ADDENDUM

Date November 12, 2014

Re Addendum No. 1 to the Bidding Documents for:

USM
Central Heat Plant Boiler Upgrade
Portland, ME
Project No. 14411

1 DOMESTIC WATER ENTRANCE SCALE: 1/2" = 1'-0"

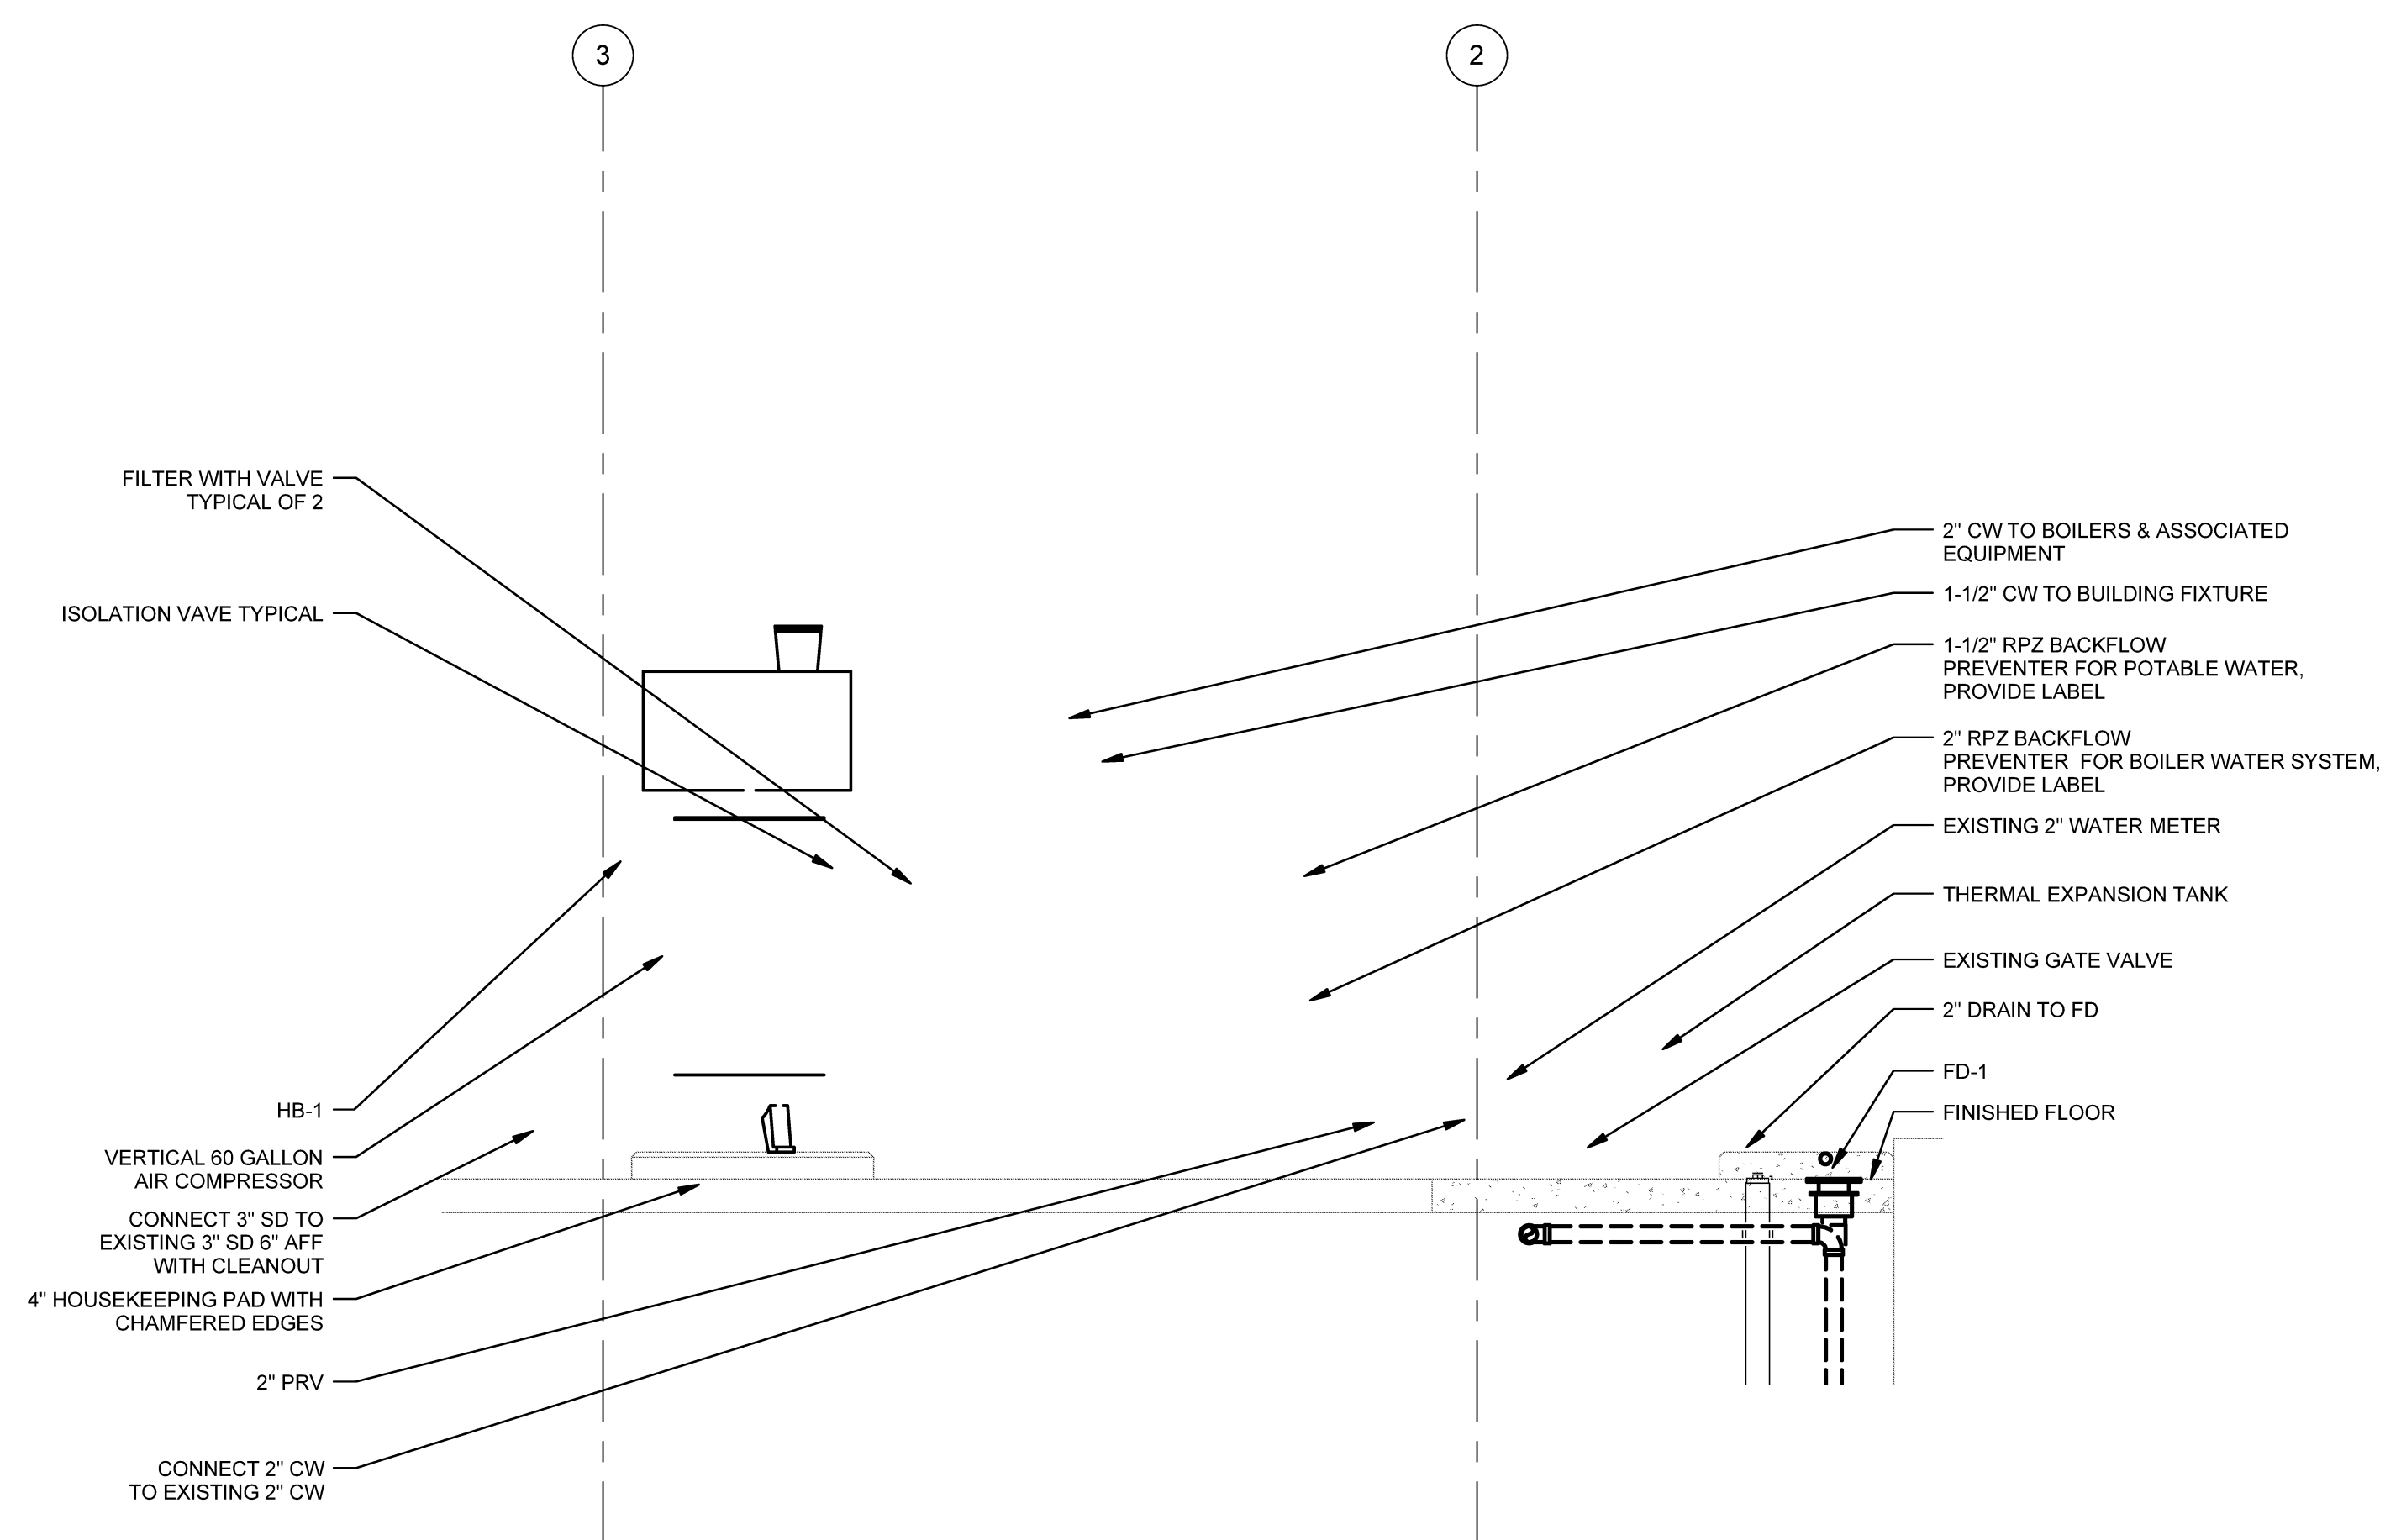
- a. General Notes – Add the following notes:
 - “6. At the Contractor’s option, John Dwyer with F.W. Webb Company (207) 541-3551 can be contacted to obtain a price to fabricate the flash tank detailed on drawing P00.1.”
- b. Delete Detail 1 and replace with sketch SKA01.

P10.3

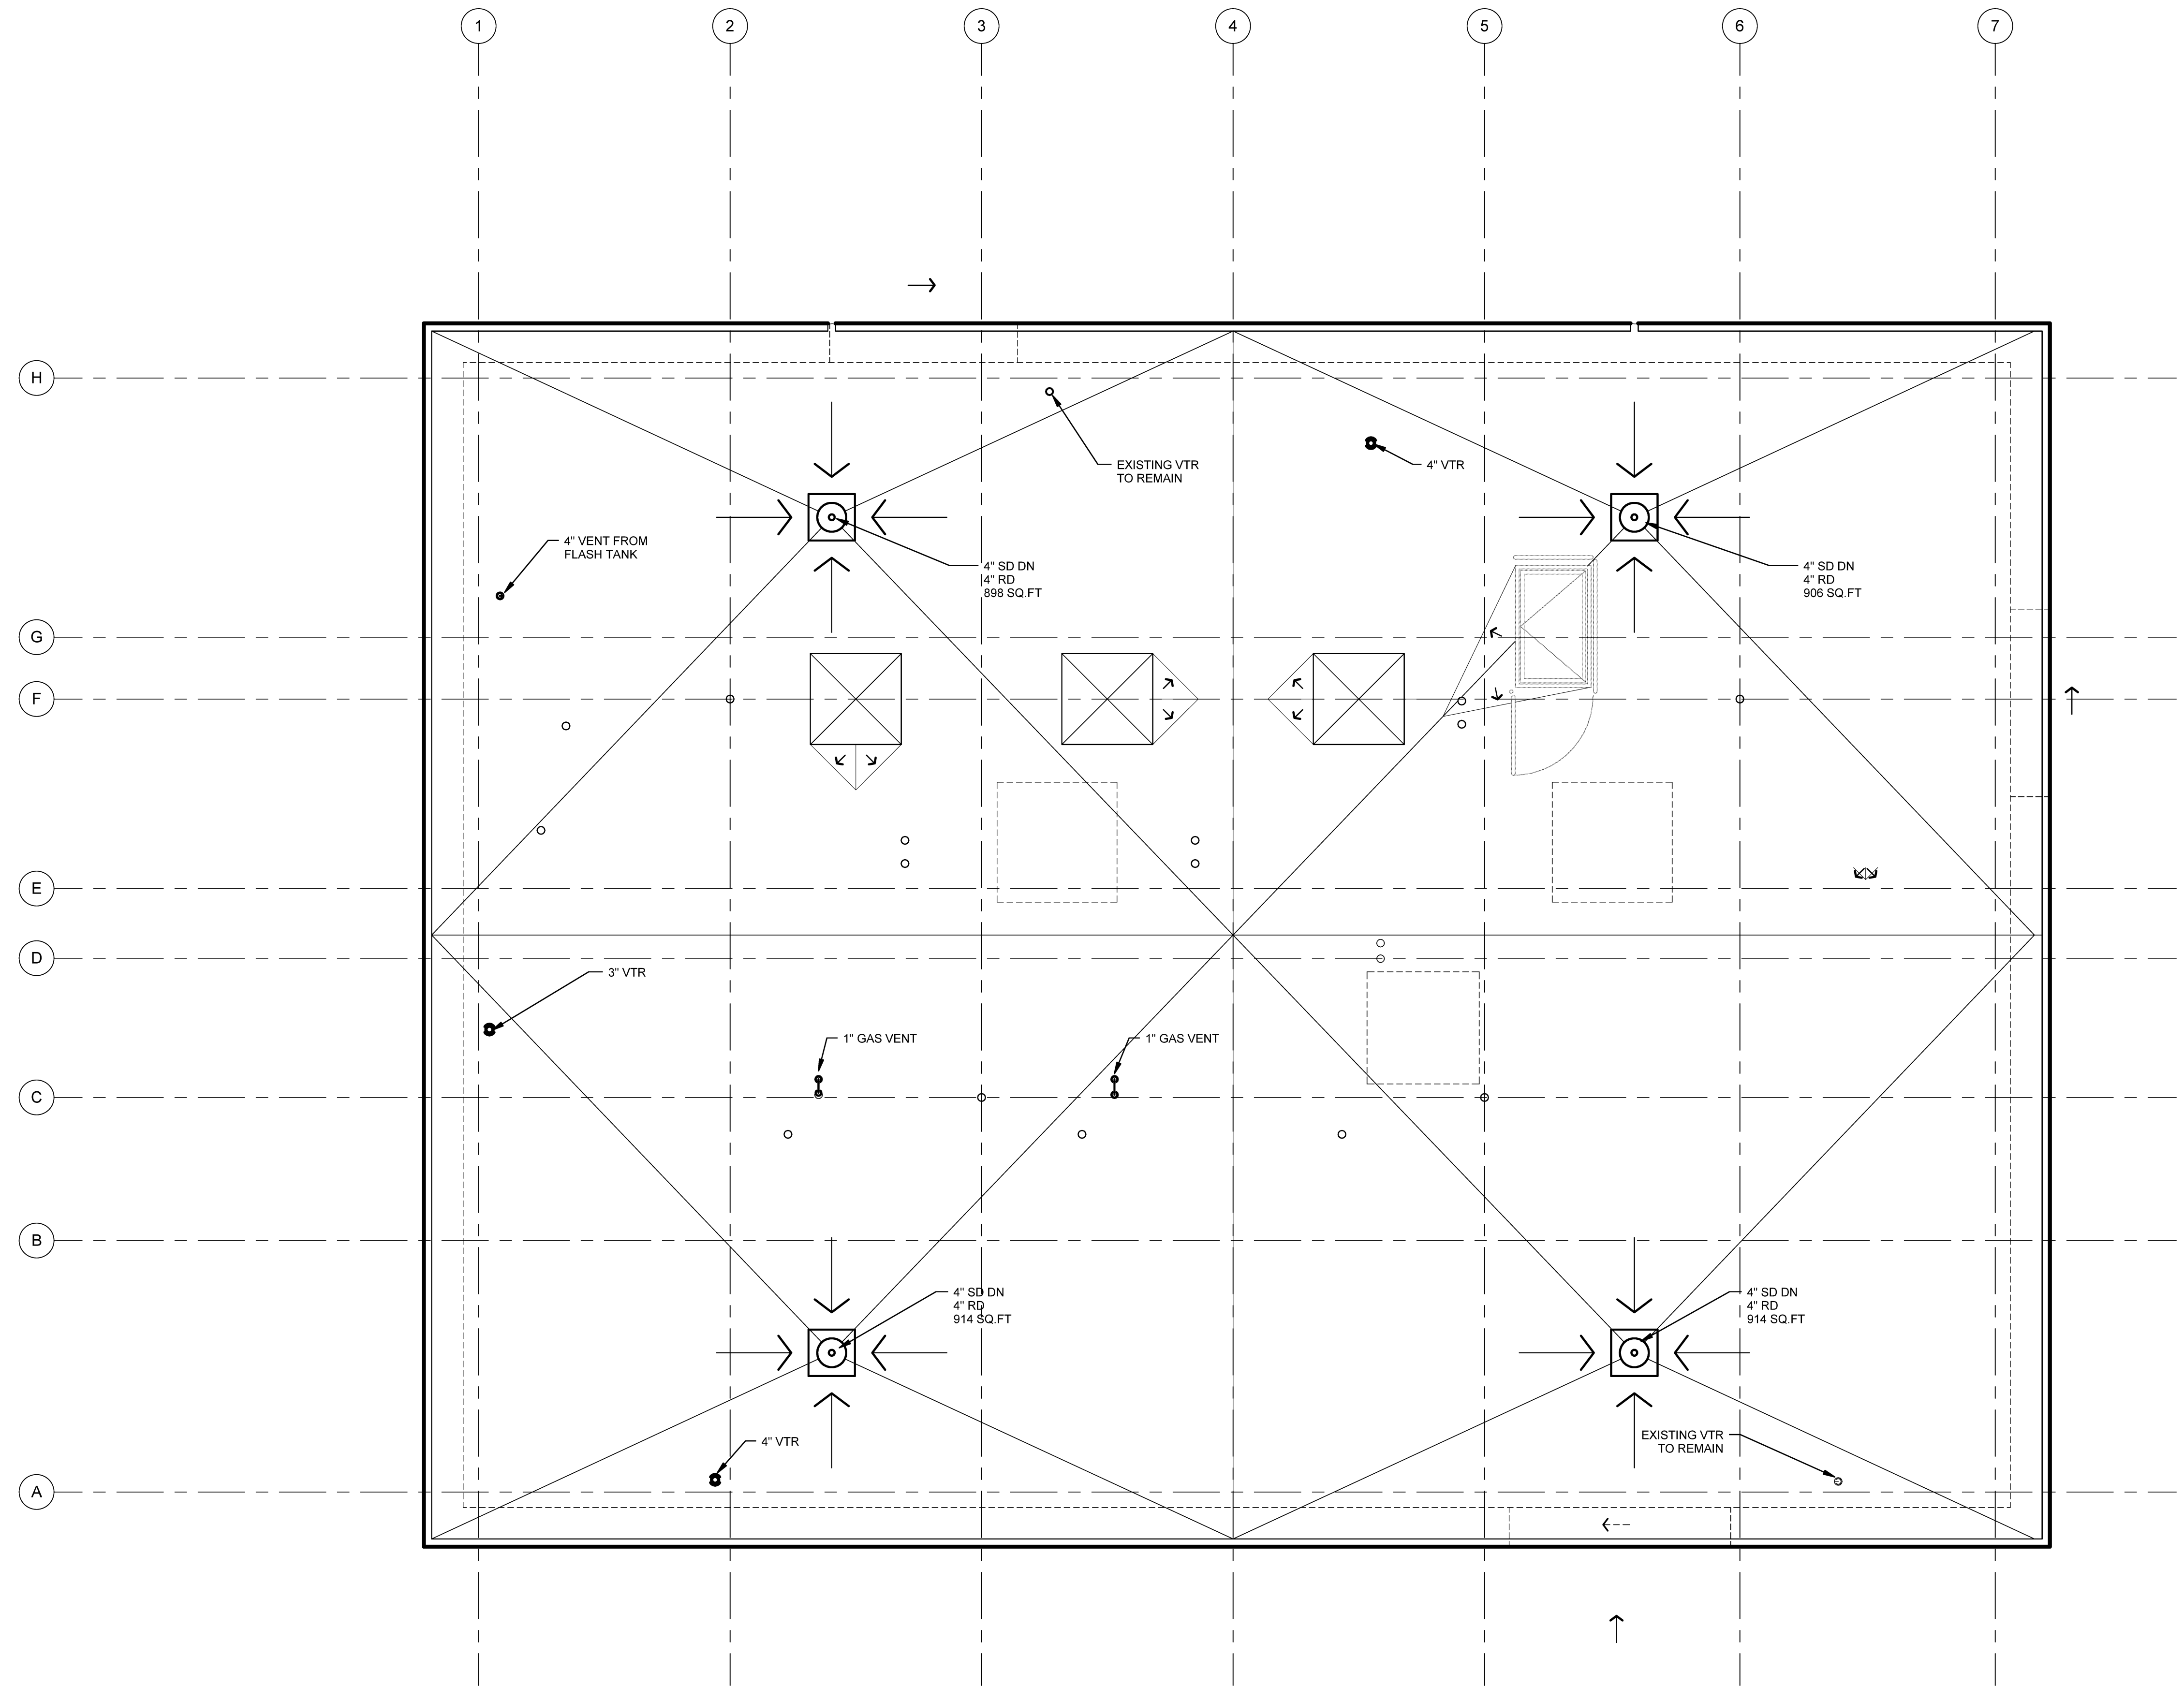
2. DRAWING P10.3 – ROOF PLAN DRAINAGE

- a. Delete notes (4 total) associated with the size of roof drains and associated storm drain piping and replace with the following:
“3 INCH SD DOWN, 3 INCH ROOF DRAIN”

M20.1

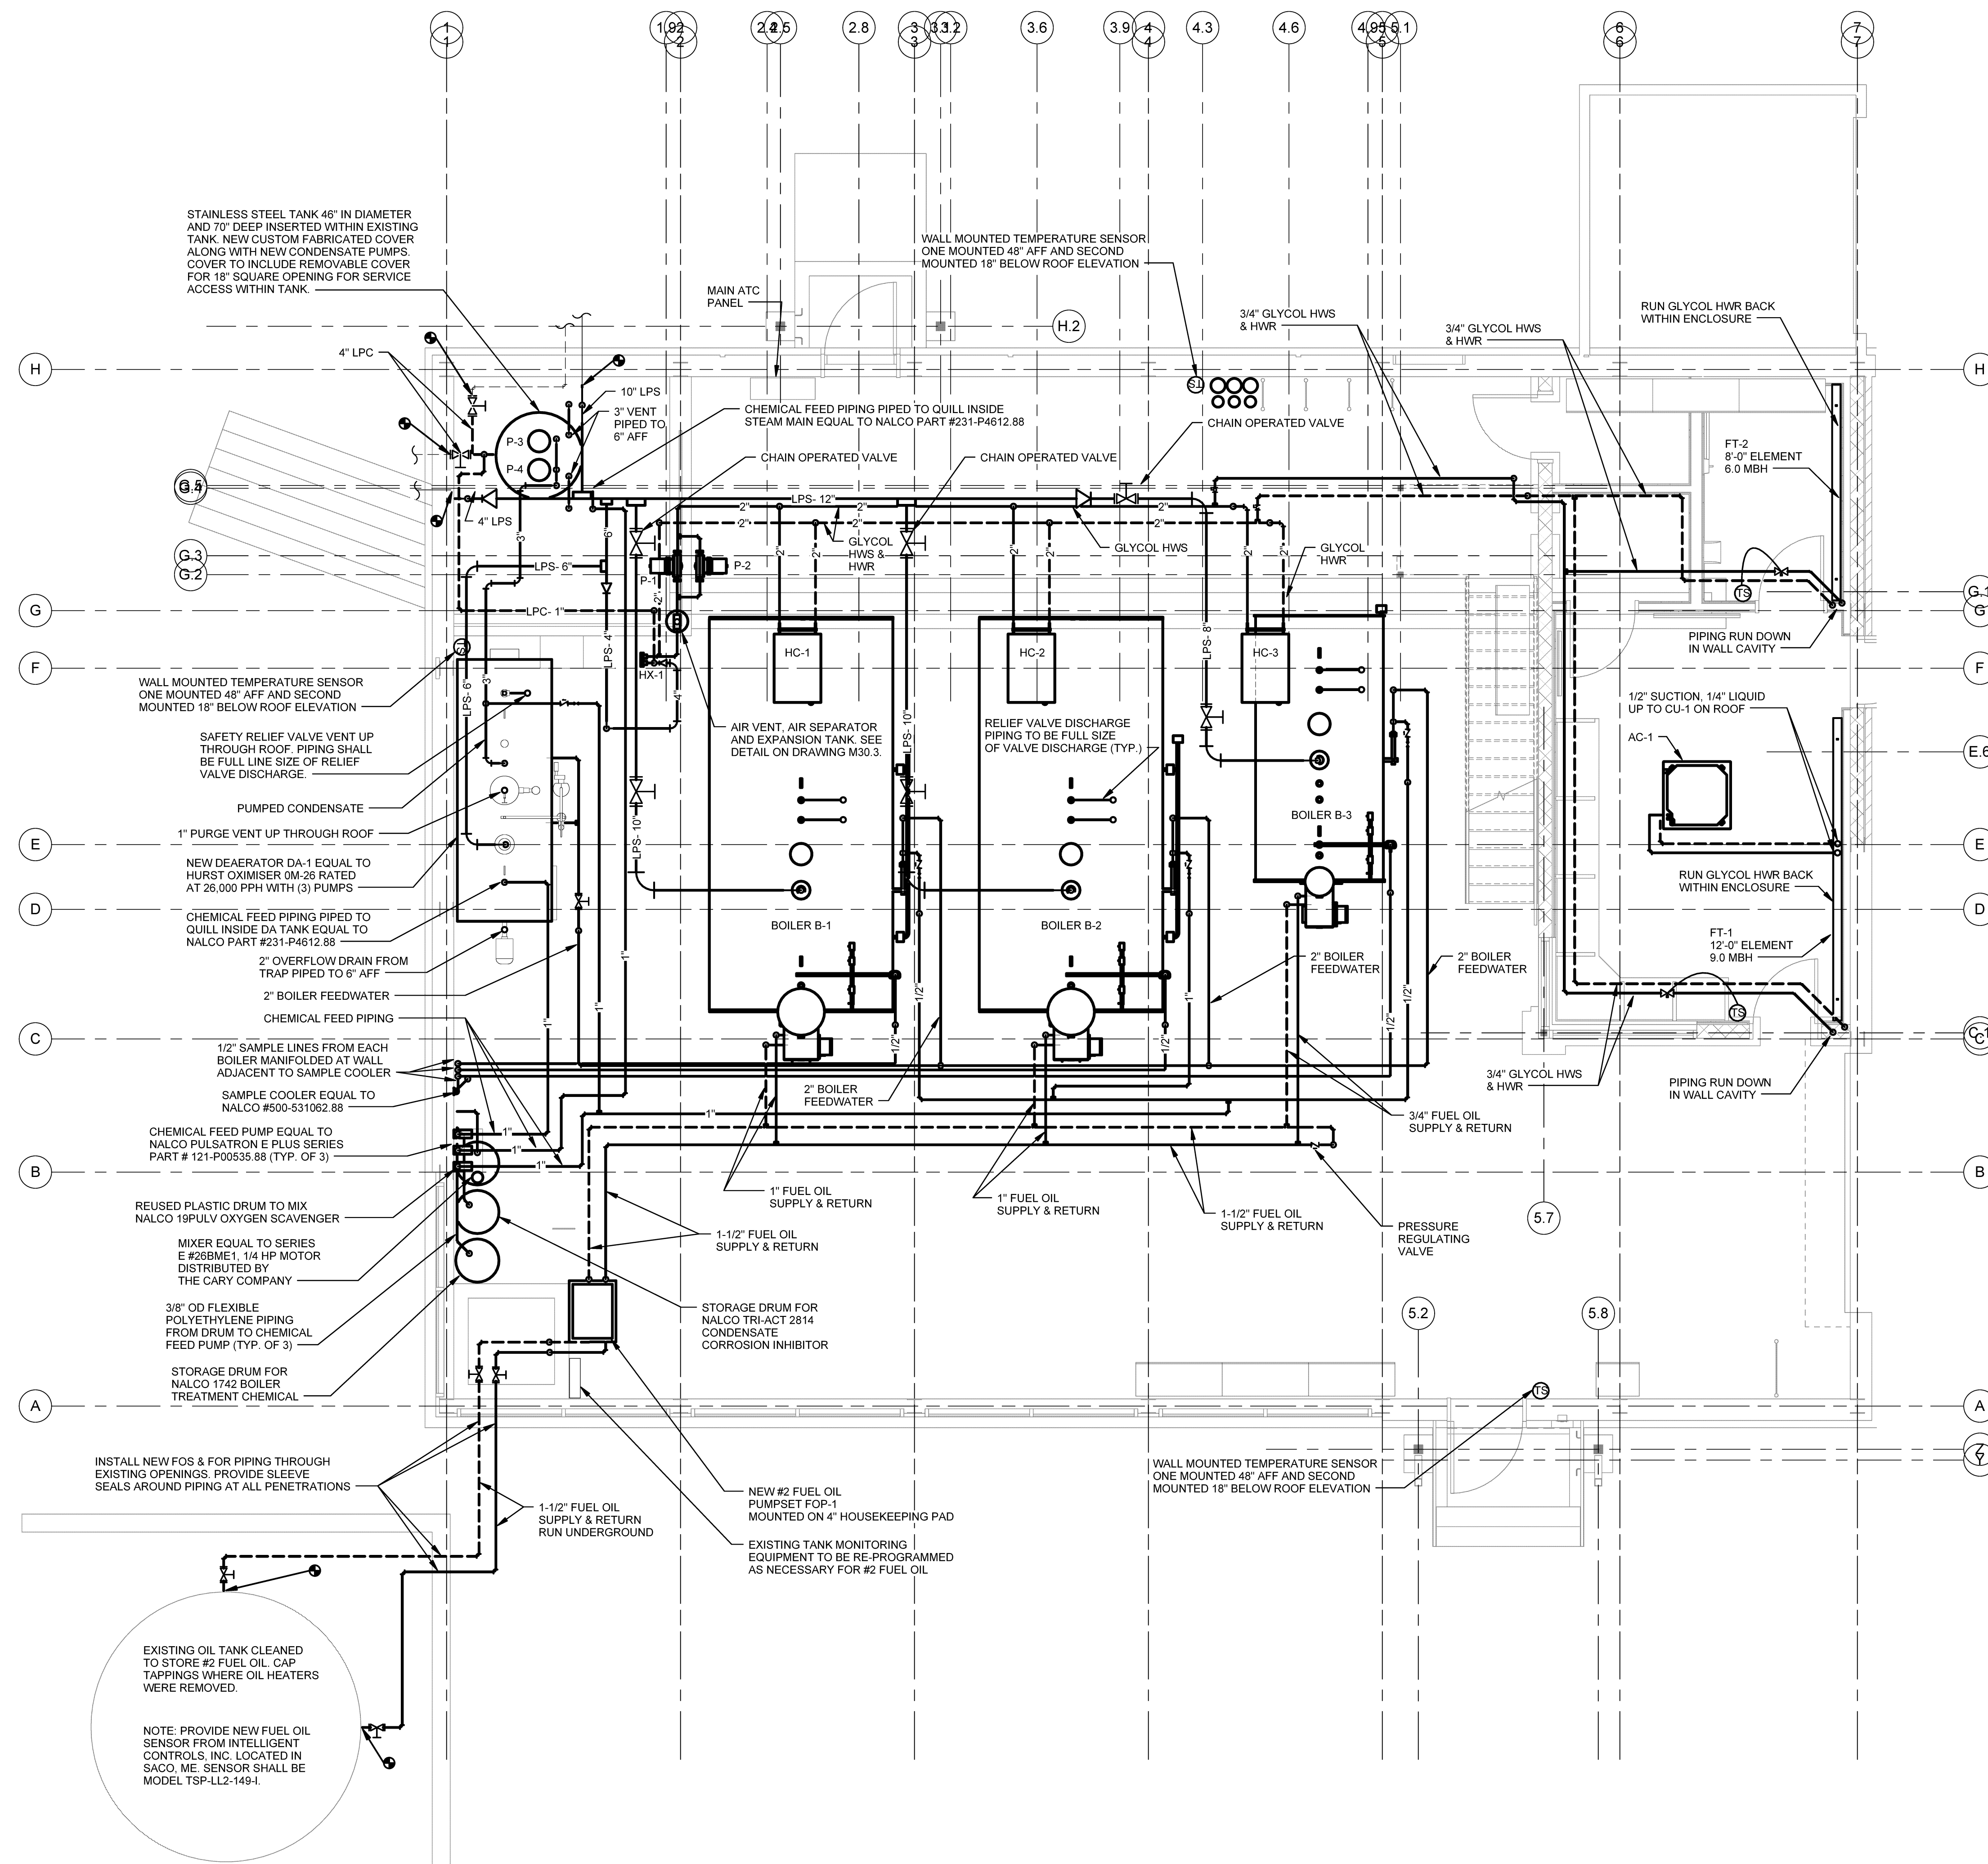
- a. General Notes – Add the following notes:
 - “11. In lieu of providing stop check valves at the low pressure steam boilers, redundant manual shut-off valves are shown in the steam main of each boiler on Drawing M20.1.
